**RE: Sunraysia Solar Farm, Balranald LGA - Environmental Impact Statement (SSD 7680)**

## ATTACHMENT A – Detailed comments for Sunraysia Solar Farm, Balranald, Environmental Impact Statement (SSD\_7680)

Figure 4. Location of recorded sites.

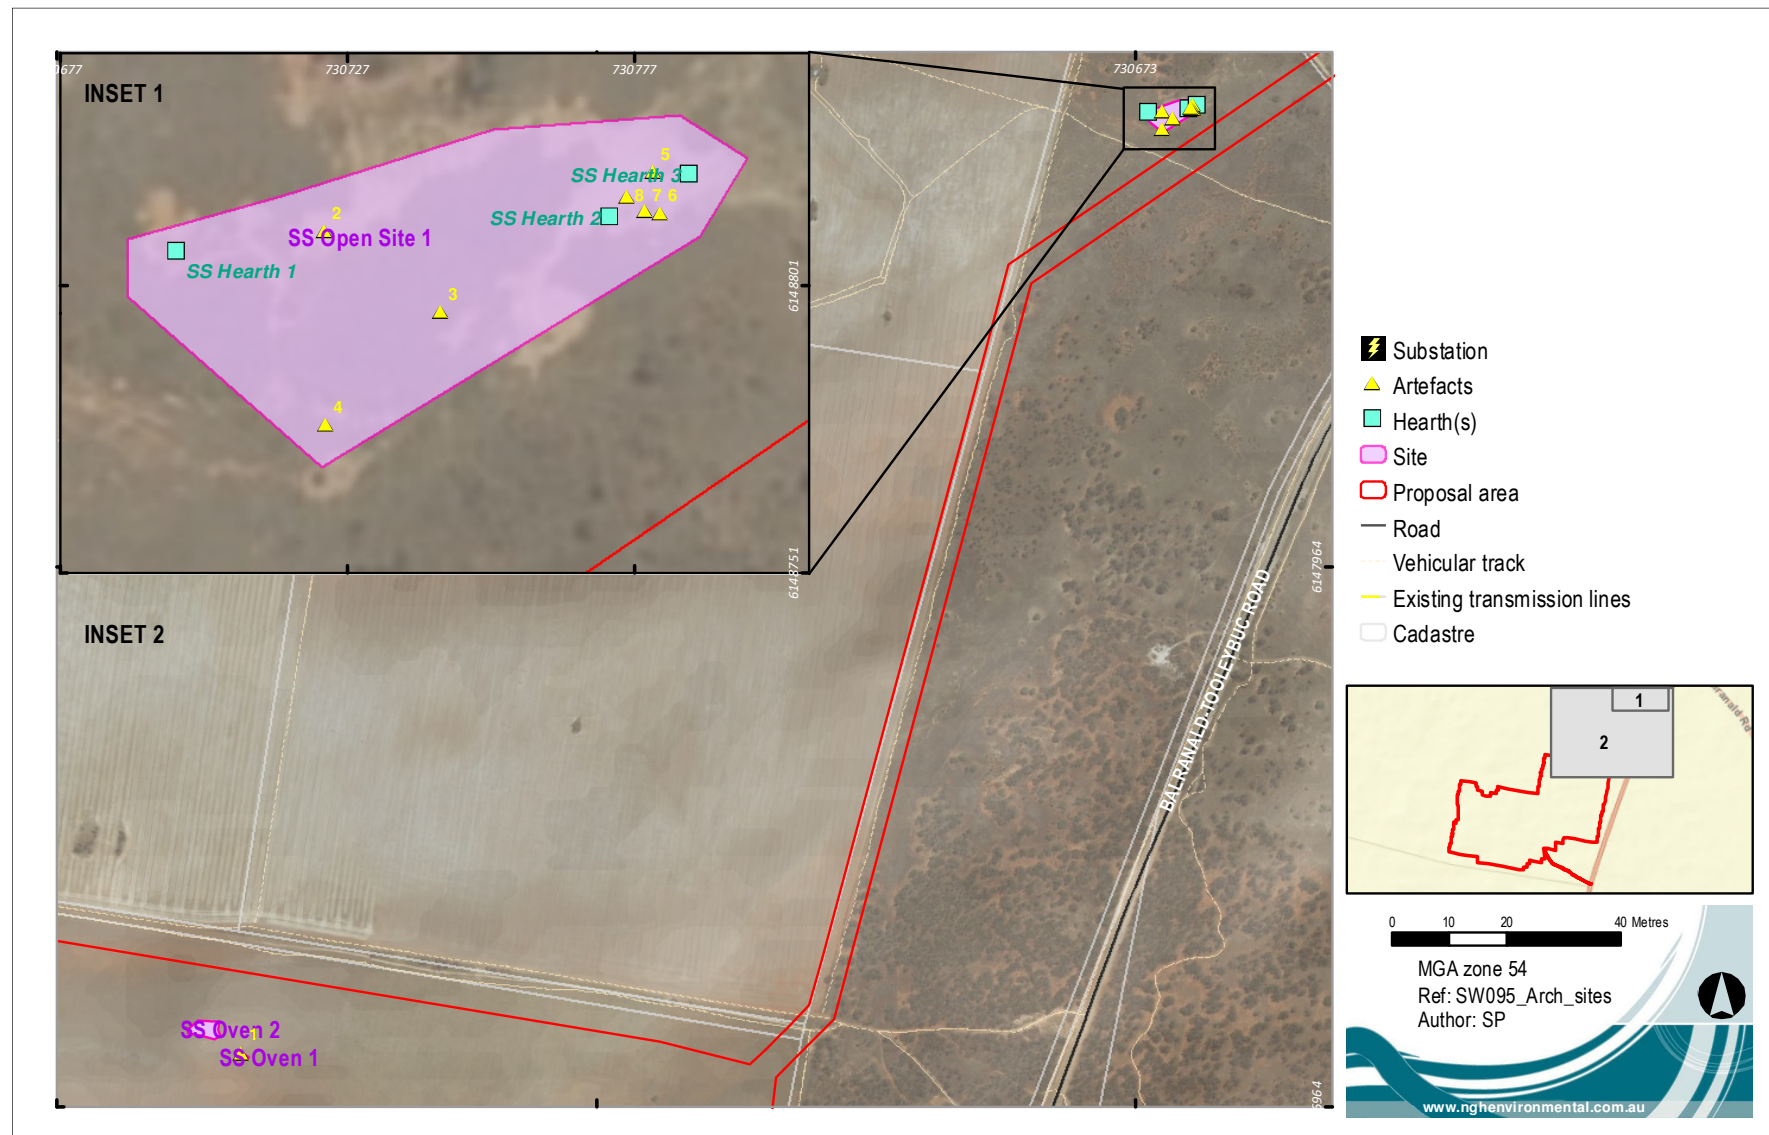
- As per recommendation 4 (Barber *et al.* 2016: 44) the proposed powerline alignment identified and mapped to avoid Sunraysia Solar Open Site 1 is required to be used. If the former easement is adopted, and the total avoidance of AHIMS 47-6-0813 is not achievable,

then further archaeological investigation must occur. This would include, but may not be exclusive too:

- Detailed program of subsurface investigation;
- Dating of any in situ deposits;
- Assessment of significance based on detailed investigation; and
- Dependent on significance, avoidance or salvage (surface and subsurface).
- The proponent is to prepare a Cultural Heritage Management Plan (CHMP) in consultation with OEH to address contingencies for:
  - Unanticipated finds protocols;
  - Reporting of suspected human remains; and
  - ACH component of site induction for employees and contractors.
- Any subsequent alterations to the development footprint that are outside the study areas of the ACH assessment and pre-clearance surveys should be assessed in accordance with the Due Diligence Code of Practice for the Protection of Aboriginal Objects in New South Wales.

Figure 3-6 PCTs within the proposal area

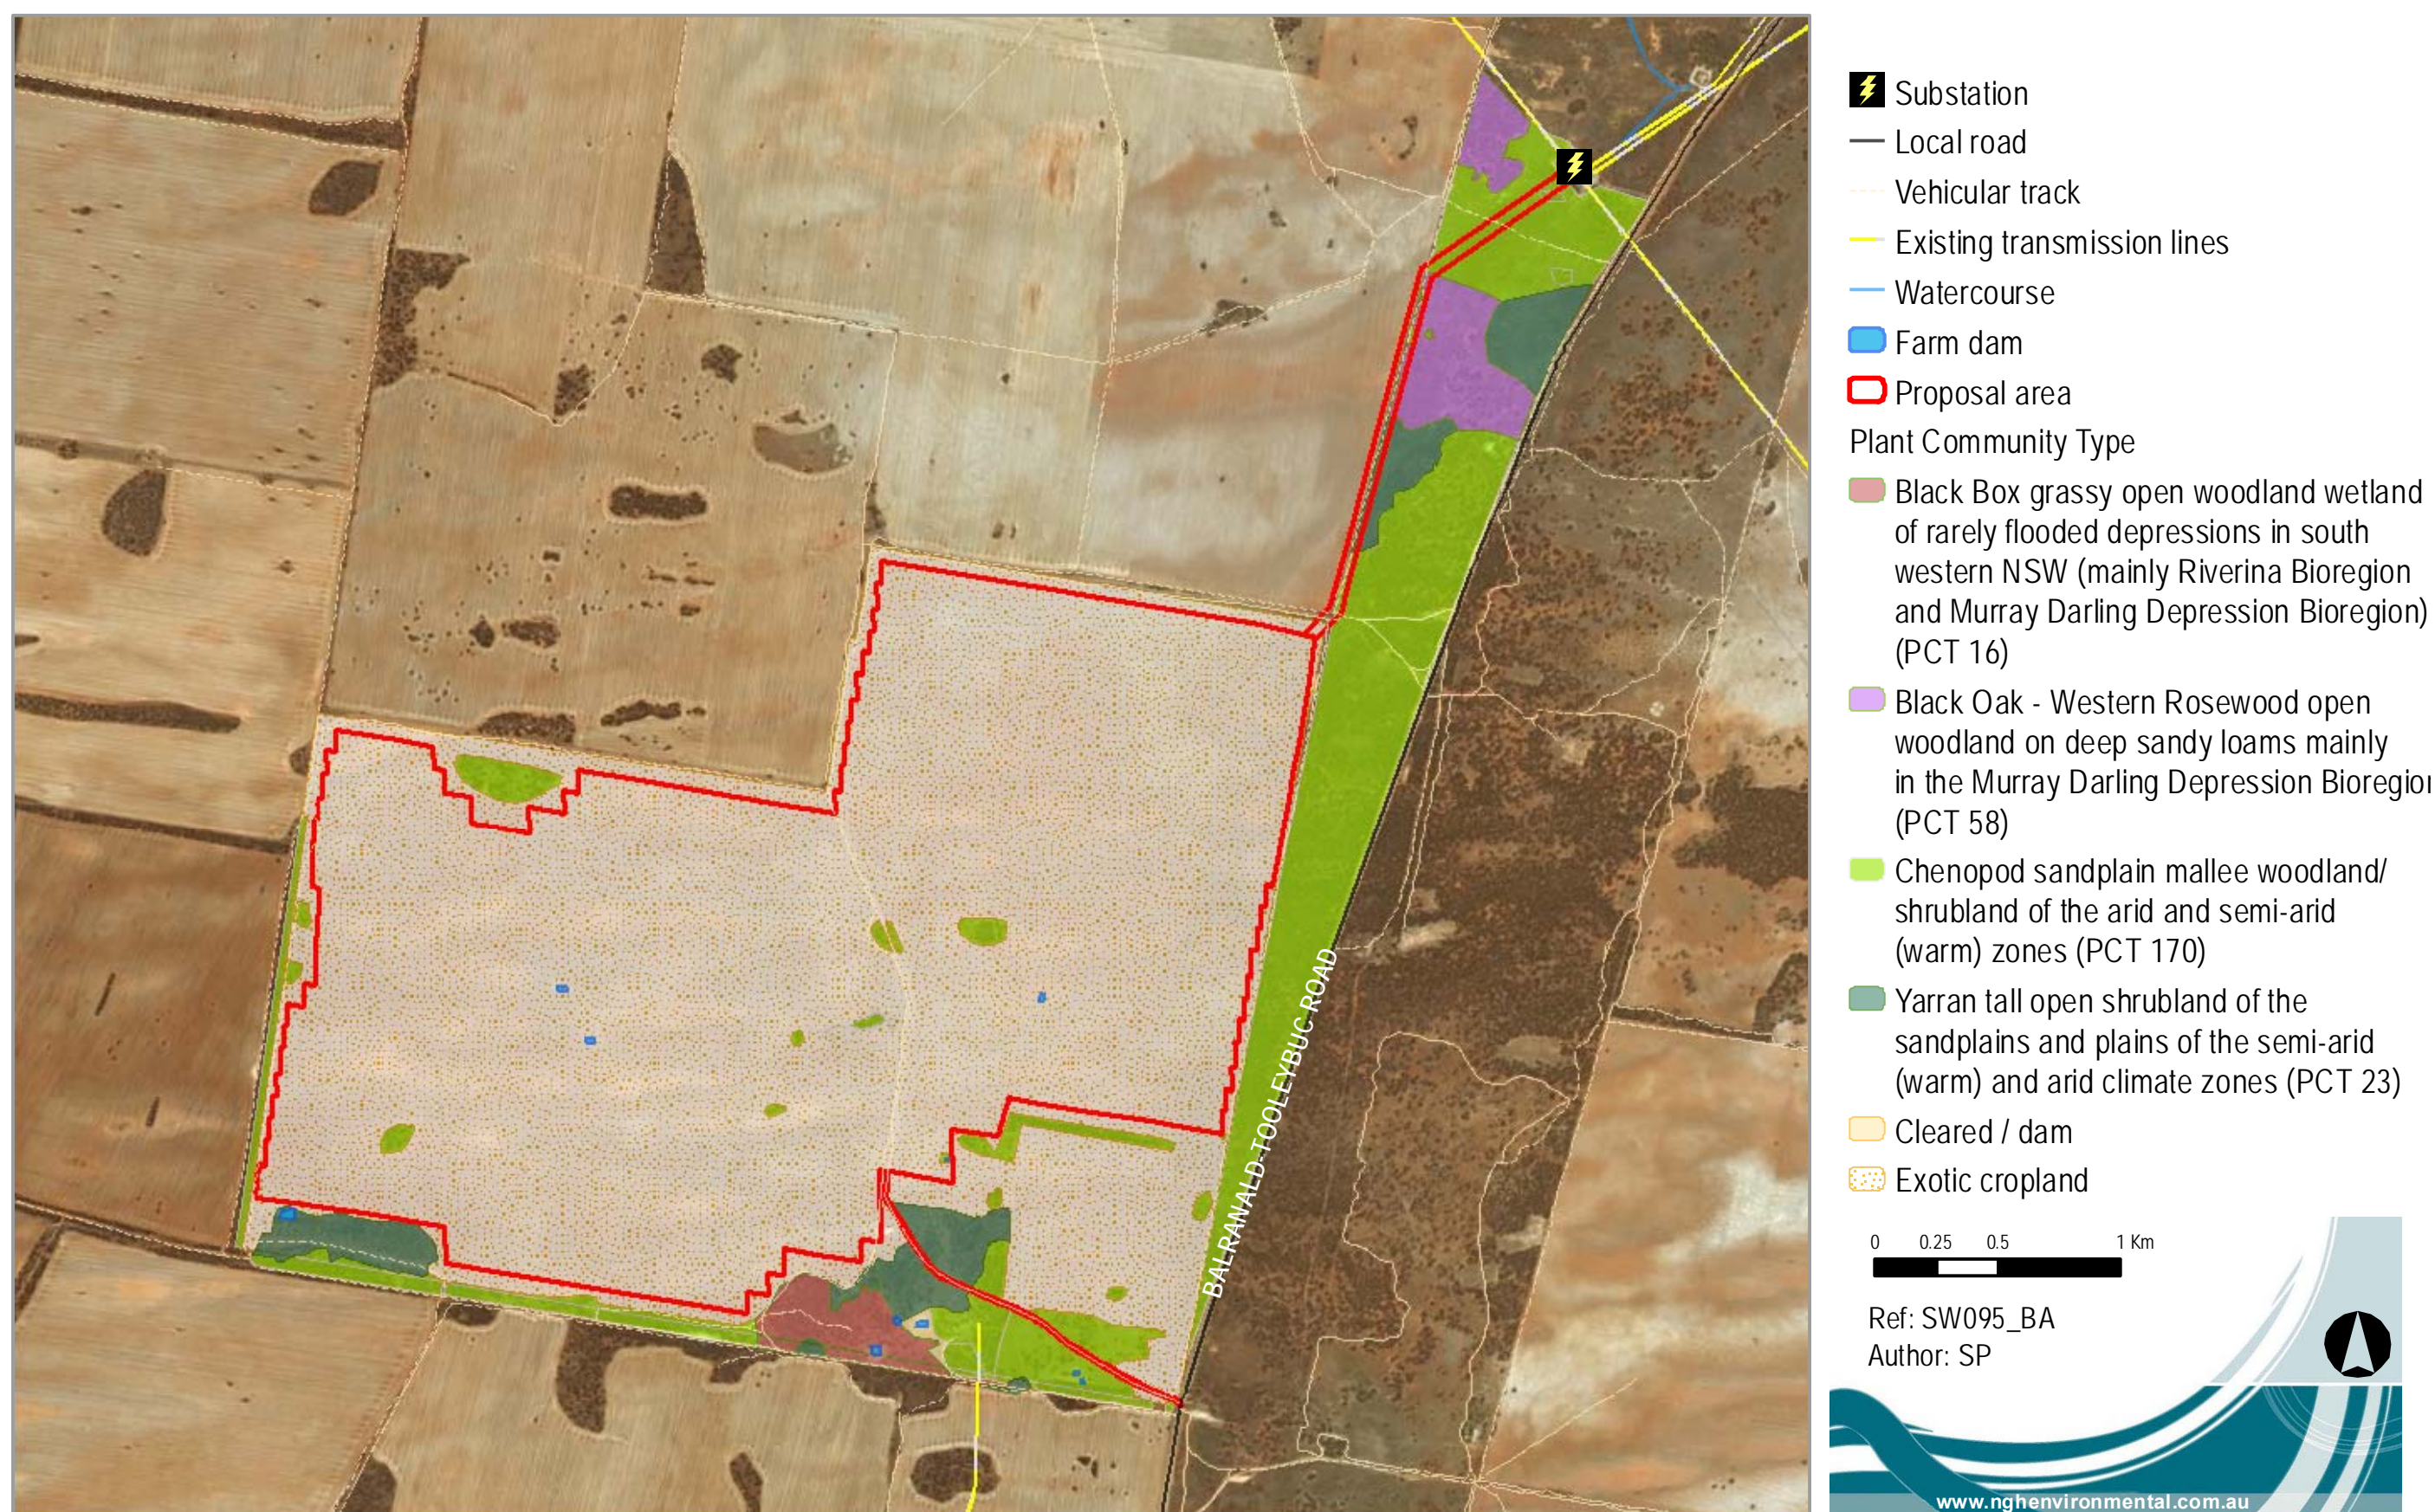
The vegetation mapping and classification appear to be well documented. We recommend checking the extent of the patches of PCT 170 'Chenopod sandplain mallee woodland' to the west of the central (north-south) vehicle track, at the approximate coordinates Easting 728201 Northing 6145470 (GDA94, Zone 54). The area of vegetation mapped in the EIS appears to be around two hectares smaller than vegetation evident on the most recent aerial imagery available to OEH.
